Local Policing Support Team

Our Ref: LM/ARU/20/08A

RE: Land at the Southern End of Cinders Lane Cinders Lane Yapton BN18 0JJ

Thank you for your correspondence of the 17th March 2020 advising me of a planning application for Approval of reserved matters following the grant of Y/32/17OUT for the erection of 19 No. dwellings. This application also lies within the parish of Climping & affects a Public Right of Way at the above location, for which you seek advice from a crime prevention viewpoint.

LOTS 1-5 | PLANS
DEVELOPMENT AT:
CINDERS LANE
YAPTON
BN18 0JJ
FOR
CRAYFERN HOMES LIMITED

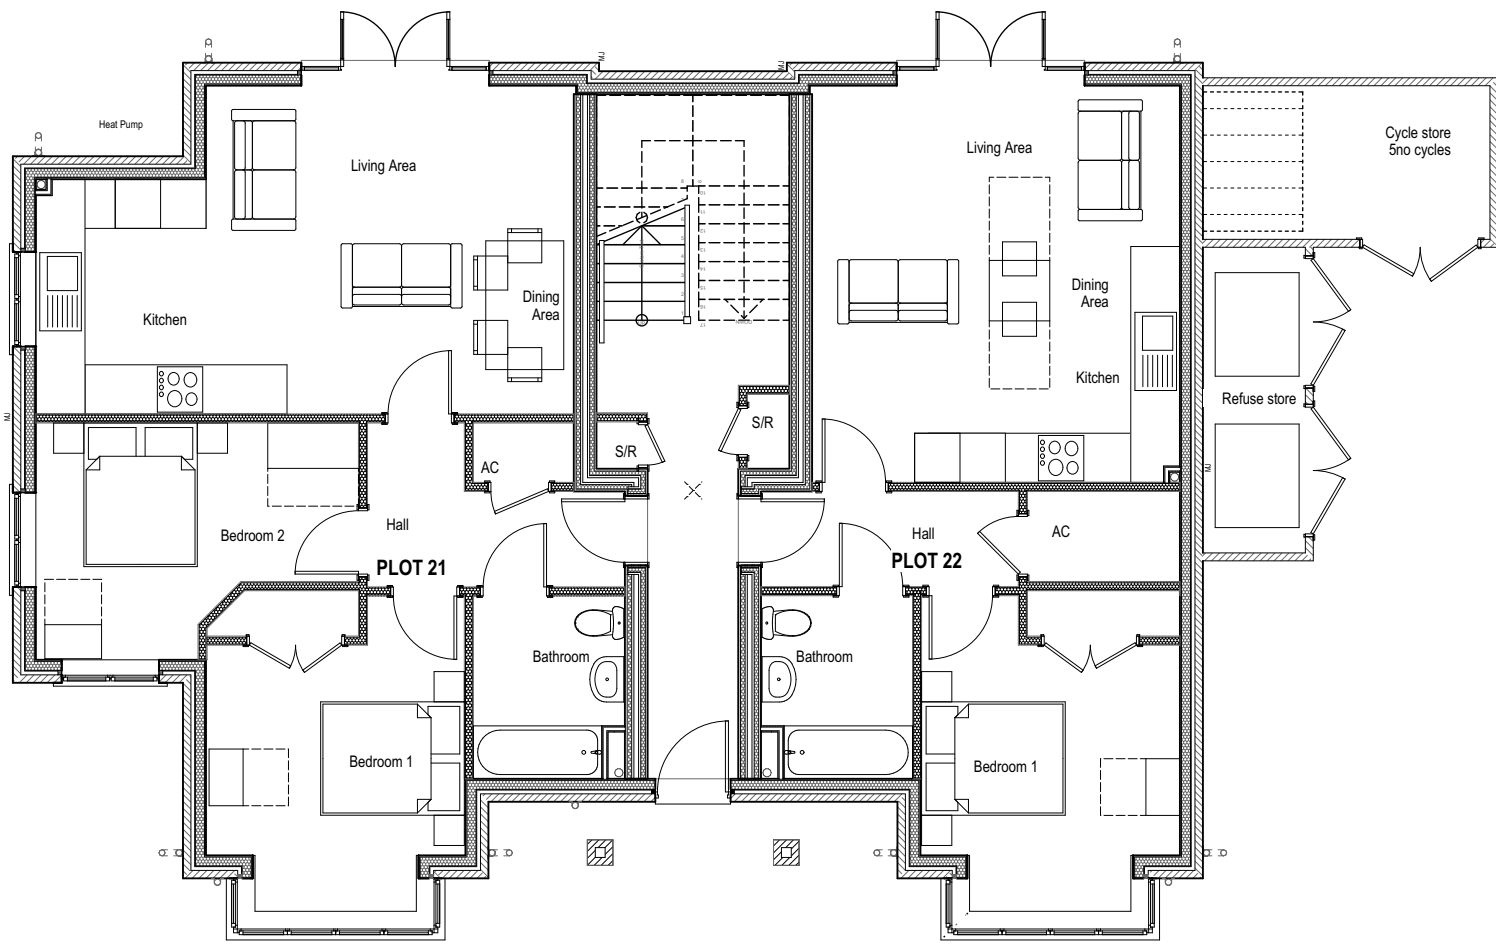
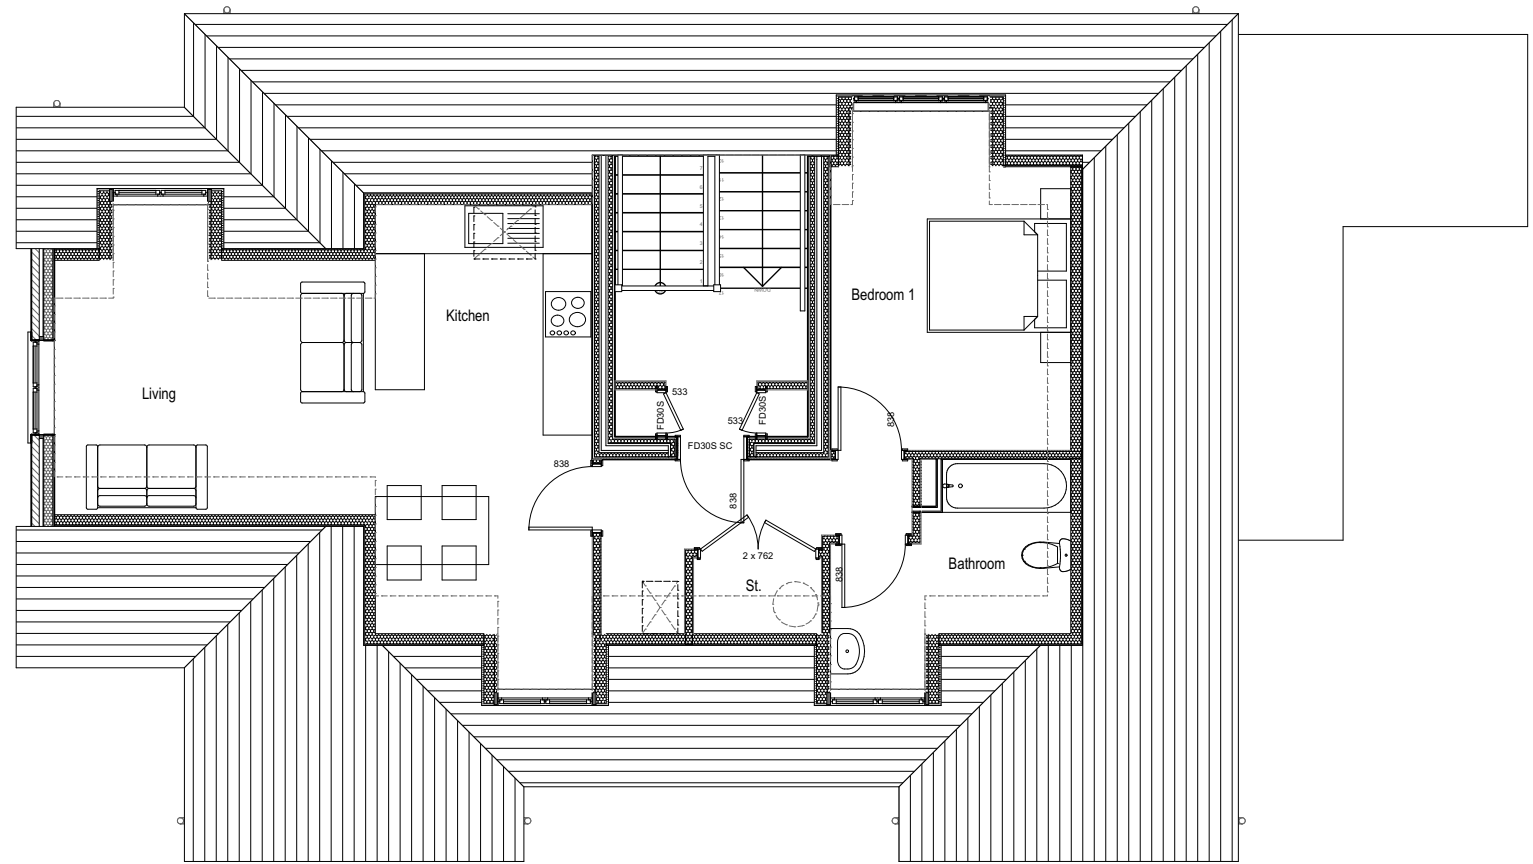
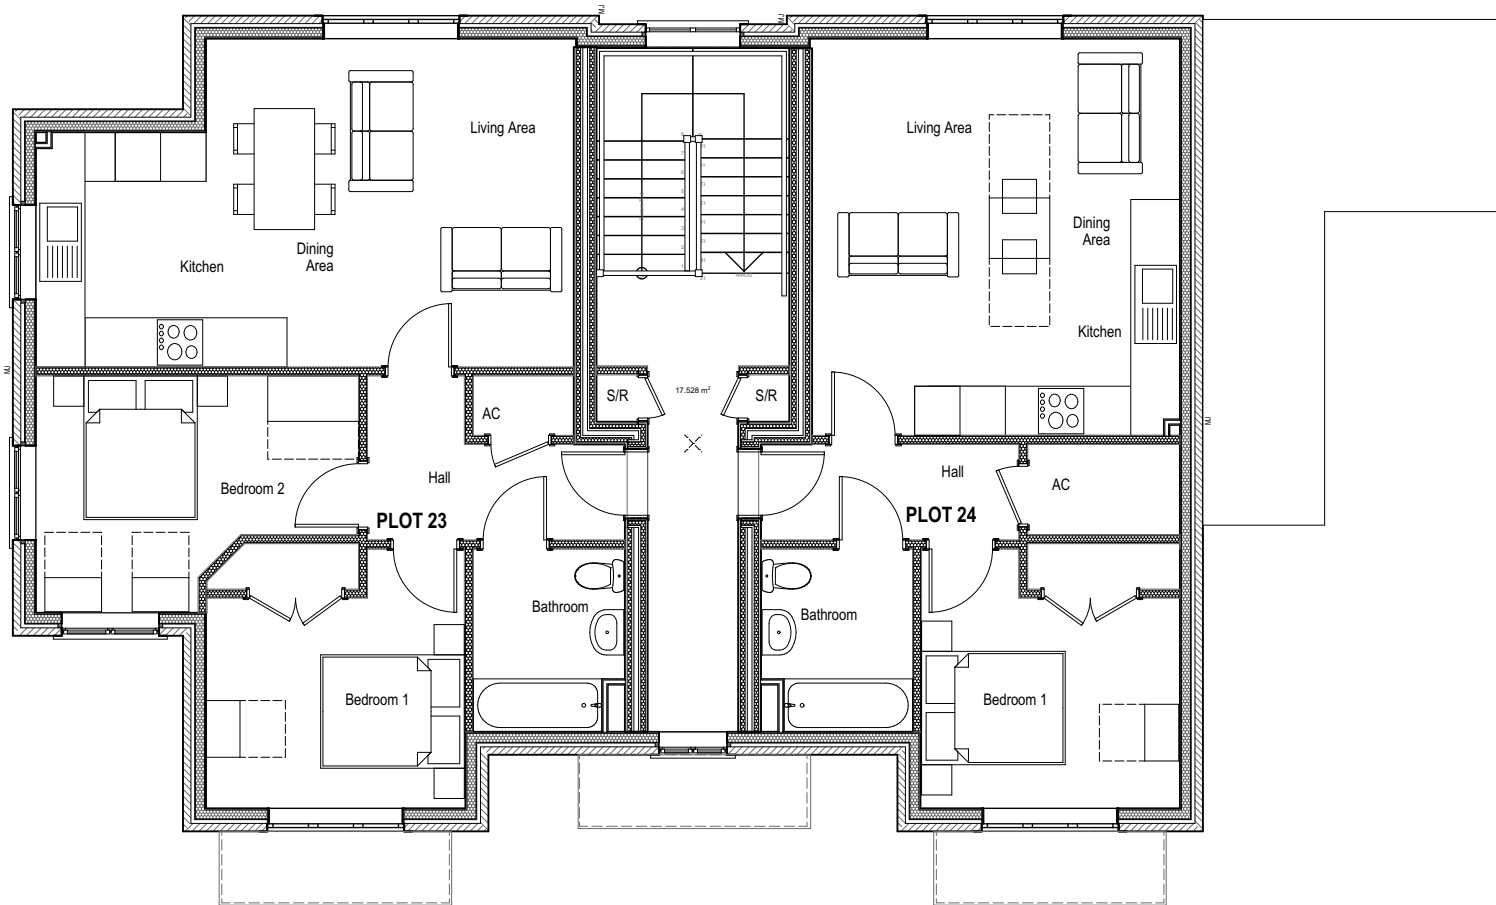
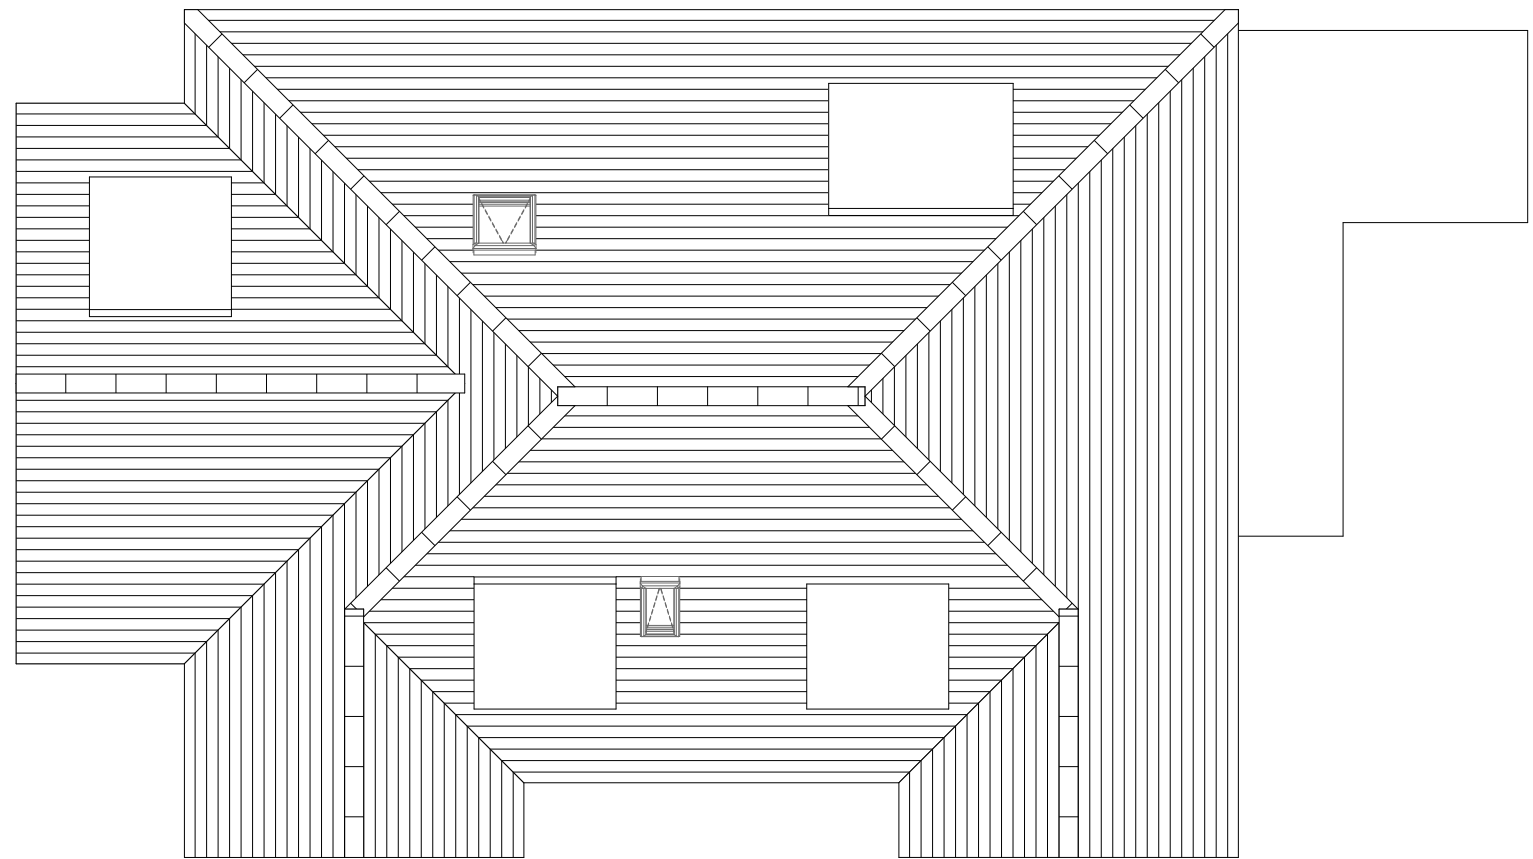
With regards to plot 1-5 (flats) - Communal entrance door-sets with a separate adjacent access control panel are usually subjected to greater use (and abuse) due to the number of dwellings served. Certification to one of the following standards can demonstrate that the door-set has a more robust construction and is more able to withstand the day to day use in a communal application than a door-set tested to PAS 024:201, PAS 024:2016 or STS201. Acceptable certification is; STS202 Issue 3 (2011) BR 2, LPS 1175 issue 7.2 (2014) SR 2+, PAS024:2012, paragraph 4.43 i.e. tested to BS EN 1627 Resistance class 3.

Door sets that are fitted with electronic locks or electronic staples must form part of the manufacturers certified range of door-sets.

I recommend the postal arrangements for the flats is through the wall, external or lobby mounted secure post boxes. I strongly urge the applicant not to consider letter apertures within the flats' front doors. The absence of the letter aperture removes the opportunity for lock manipulation, fishing and arson attack and has the potential to reduce unnecessary access to the block.

Additionally Chapter 56 SBD Homes 2019 refers to external communal bicycle storage. This will be of particular pertinence to plot 1-5 (flats) as 56.3 states that external, open communal bicycle stores with individual stands or multiple storage racks for securing bicycles will be as close to the building as possible, but in any event within 50 metres of the primary entrance to a block of flats and located in view of active rooms (Note 56.3) of dwellings. The store must be lit at night using vandal resistant, light fittings and energy efficient LED lights.

Additionally, with regards to plot 1-5 (flats) SBD Homes 2019 Chapter 57 refers to integral communal bin, mobility vehicles and bicycle stores. 57.1 states that integral communal bin, mobility vehicles and bicycle stores within blocks of flats should be easily accessible, with floor to ceiling dividing walls, no windows and be fitted with a secure doorset that meets the same physical specification as 'front door' and specifically Section 2a, paragraphs 21.1 to 21.21. This will ensure that such stores are only accessible to residents.

The locking system must be easily operable from the inner face by use of a thumb turn to ensure that residents are not accidentally locked in by another person. A bicycle store must also be provided with stands with secure anchor points or secure cycle stands (see paragraph 56). 57.2 In England and Wales, doorsets providing access from the storage facility into communal parts of the building (including emergency egress doorsets) are required to meet Part B, Part M and Part Q of Building Regulations. 57.3 Any doorset that provides access to the communal areas shall also be controlled via an access control system.
